March 24, 2017

Comments for 2440 Louisiana NE

Response to comments in RED by DPS.

DRAINAGE NARRATIVE

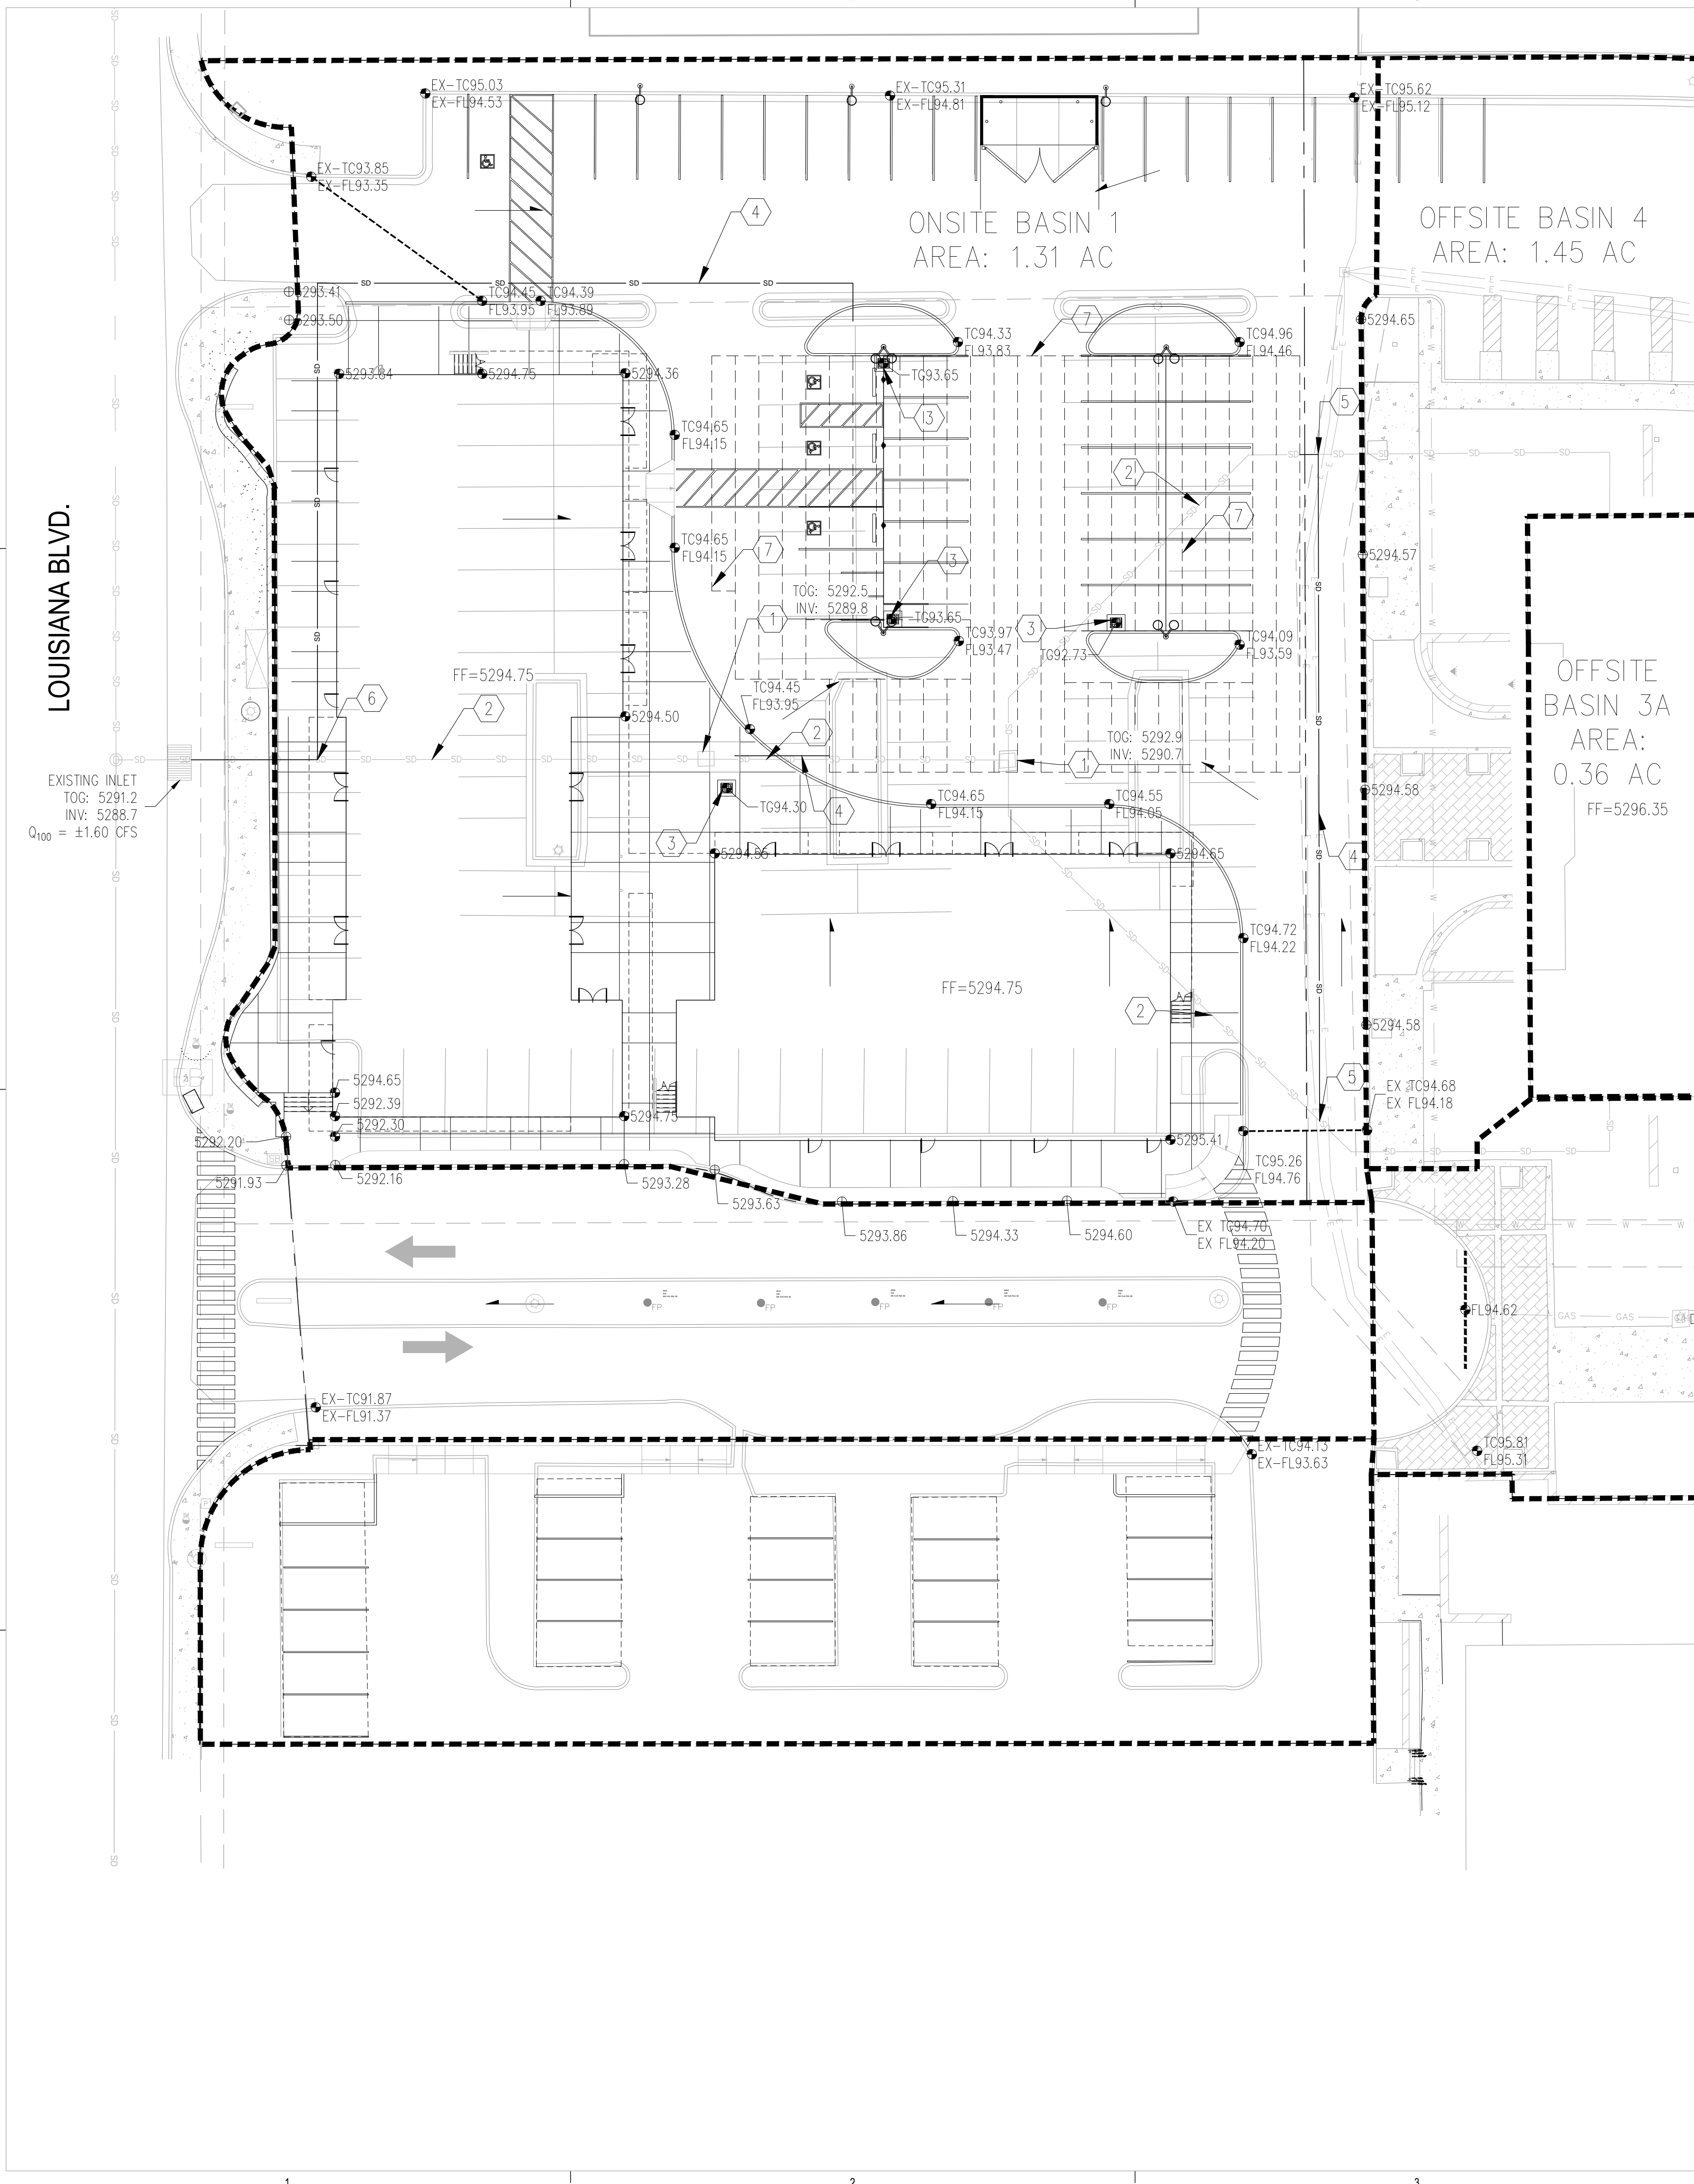
A grading and drainage plan is required. First flush volume requirements have to be addressed.

A grading and drainage plan was provided that includes a narrative concerning the first flush. (RE: Sheet 08) The underground pond proposed will have volume to accommodate the first flush requirements.
